# Rezoning Transportation Analysis

Petition Number: 2021-079

**Reviewer: Walta Blackmon, PE**

Date	Description
08-02-2021	First Review (WB)
08-23-2021	Second Review (WB)

DRAWING NO.: **RZ-01**

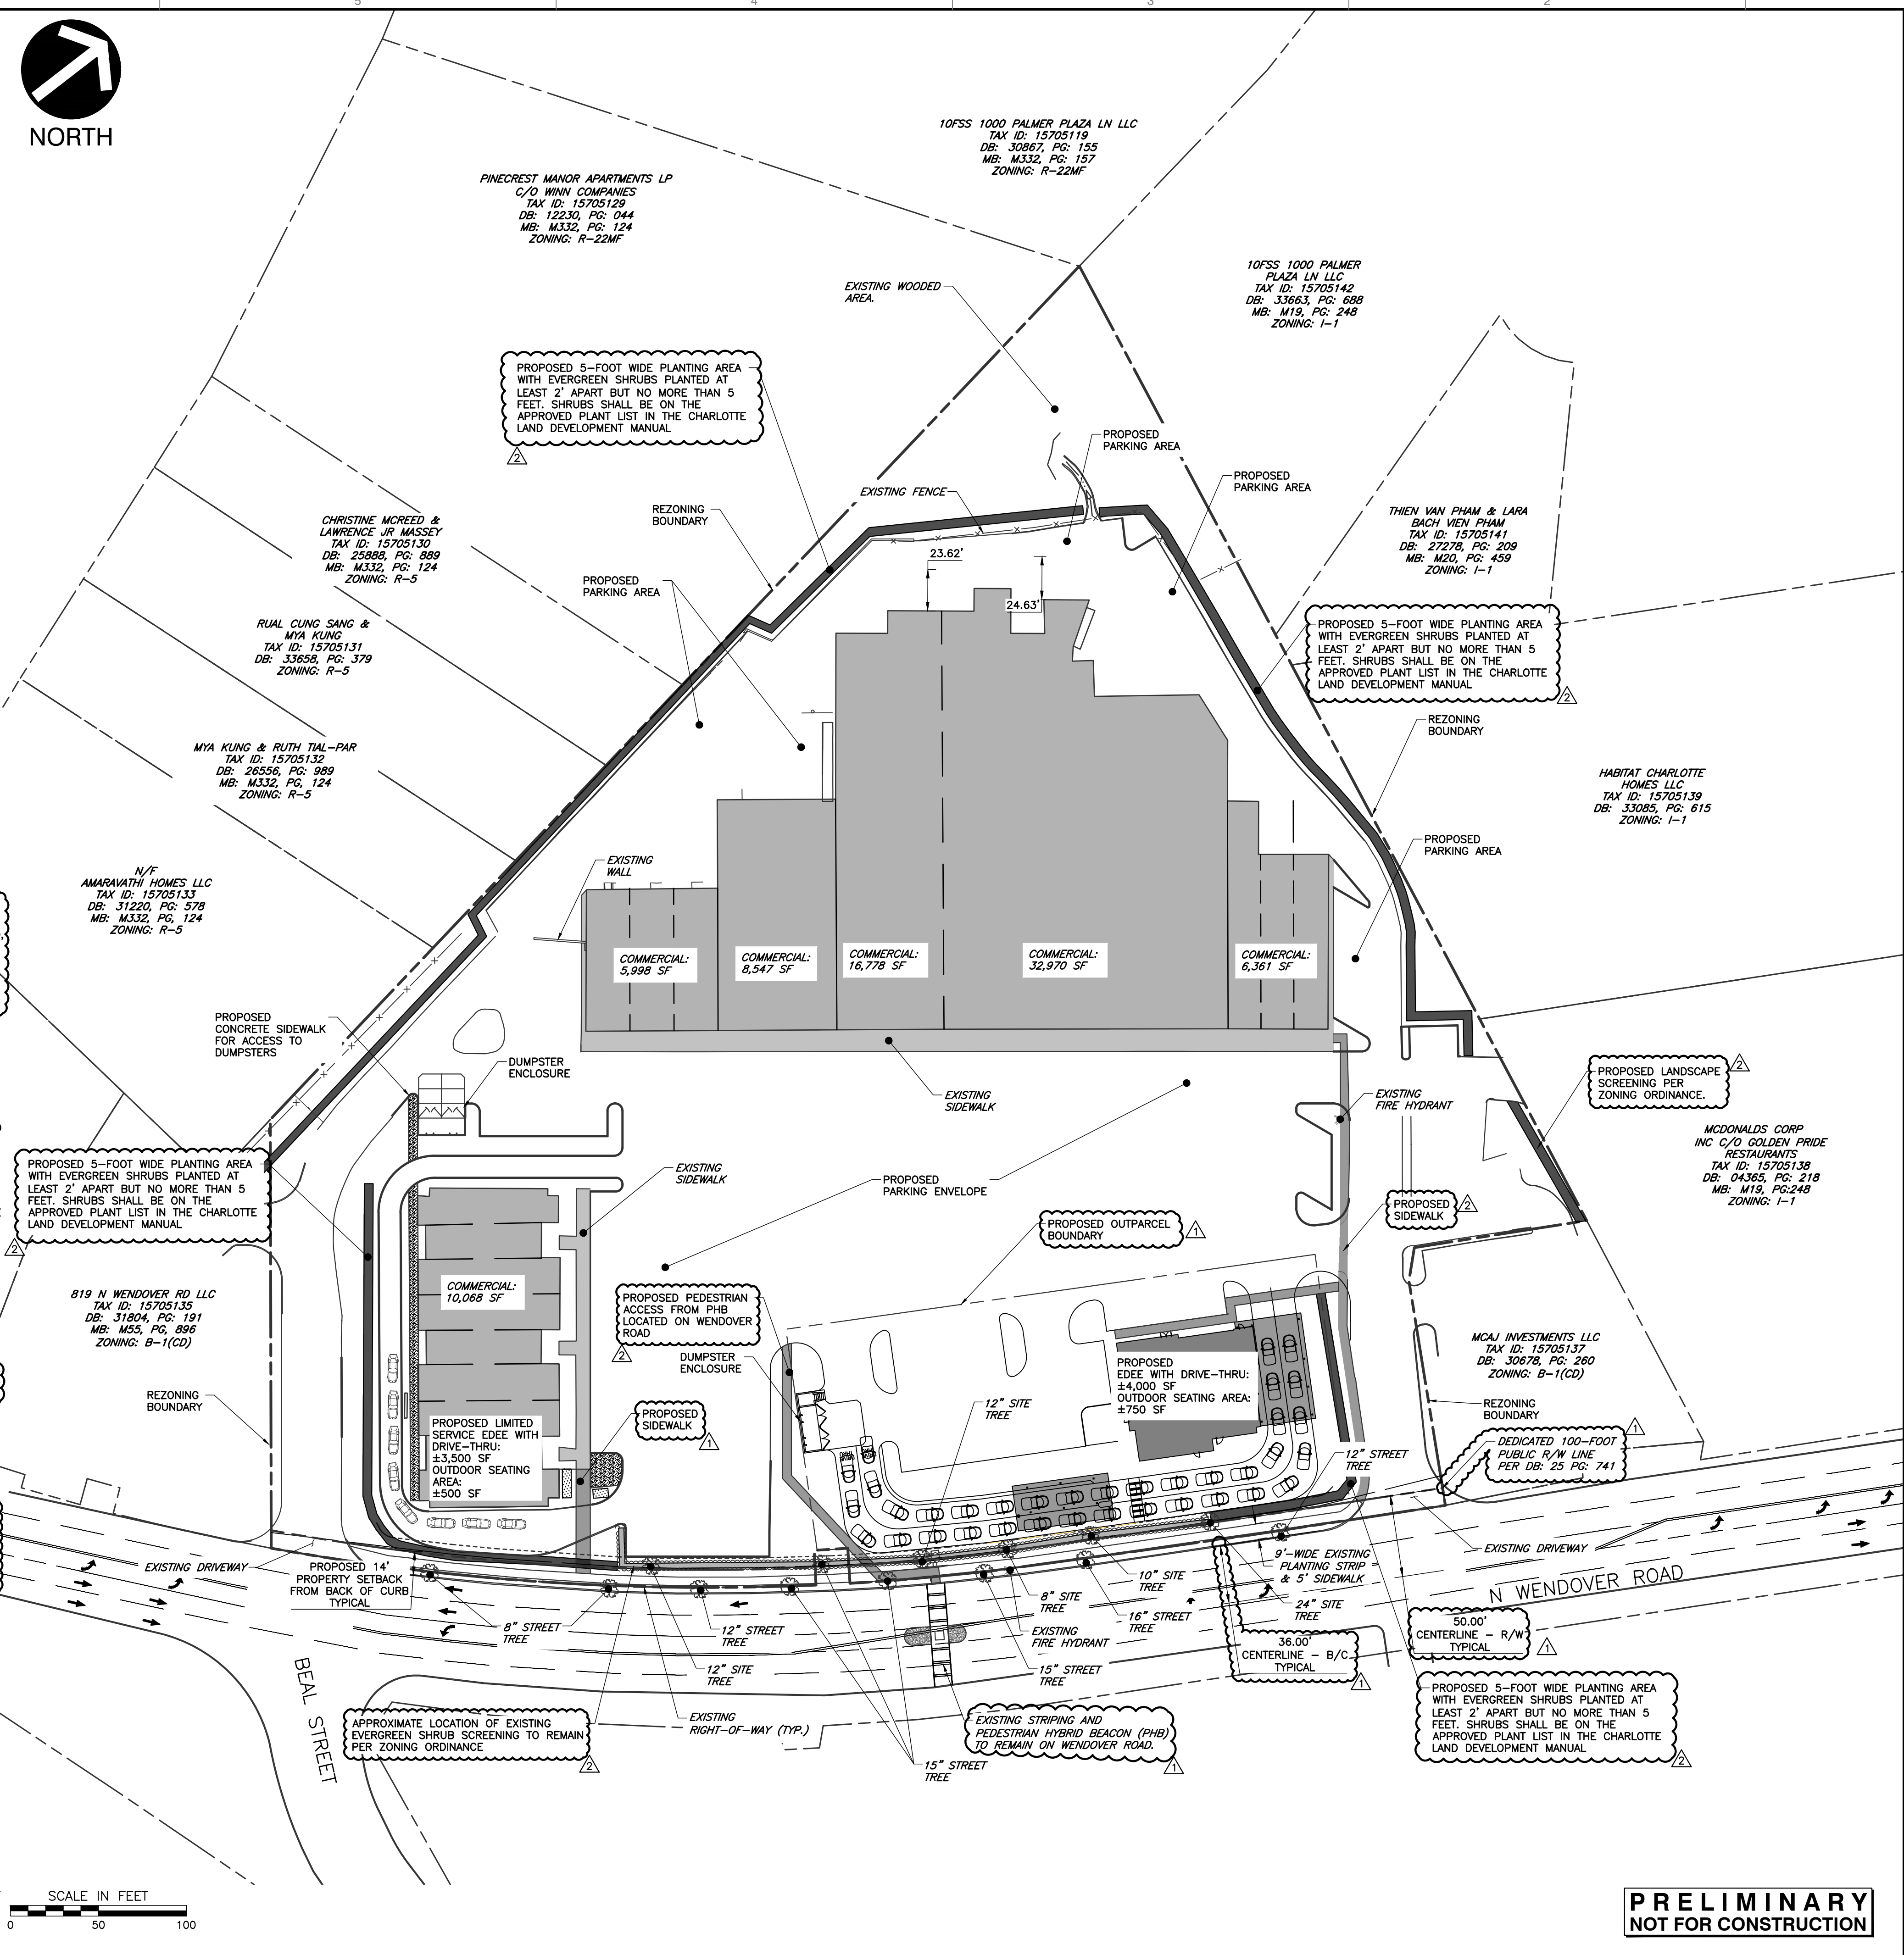
2. **Traffic Study:**

A Traffic Impact Study is necessary for the complete review of this petition due to the site generating more than 2,500 daily trips.

Staff will receive the petition and begin review, but the public hearing will not be scheduled until the TIS is approved to allow for the minimum time necessary for CDOT to review the study and reach agreement with the petitioner on the required transportation commitments. Any agreed upon commitments shall be included on the last site plan submitted no fewer than 4 weeks prior to the public hearing. Therefore, additional traffic mitigation comments may be forthcoming once the TIS is approved by CDOT (and NCDOT).

4. Site plan and conditional note(s) revisions are needed to commit to installing a 12' multi-use path with an 8' planting strip along the site's frontage of Wendover Road to meet the Charlotte BIKES Policy.

6. Revise site plan and conditional note(s) to commit to provide convenient pedestrian access from the PHB into the site without crossing the drive thru.

Approximate location of Proposed Pedestrian Access

7. Add a site plan note specifying dedication and fee simple conveyance of all rights-of-way to the City before the site's first building certificate of occupancy is issued.
- ~~8. Add a site plan note specifying that all transportation improvements will be approved and constructed before the site's first building certificate of occupancy is issued. The petitioner may phase transportation improvements if said improvements and phasing are explicitly described in site plan notes.~~
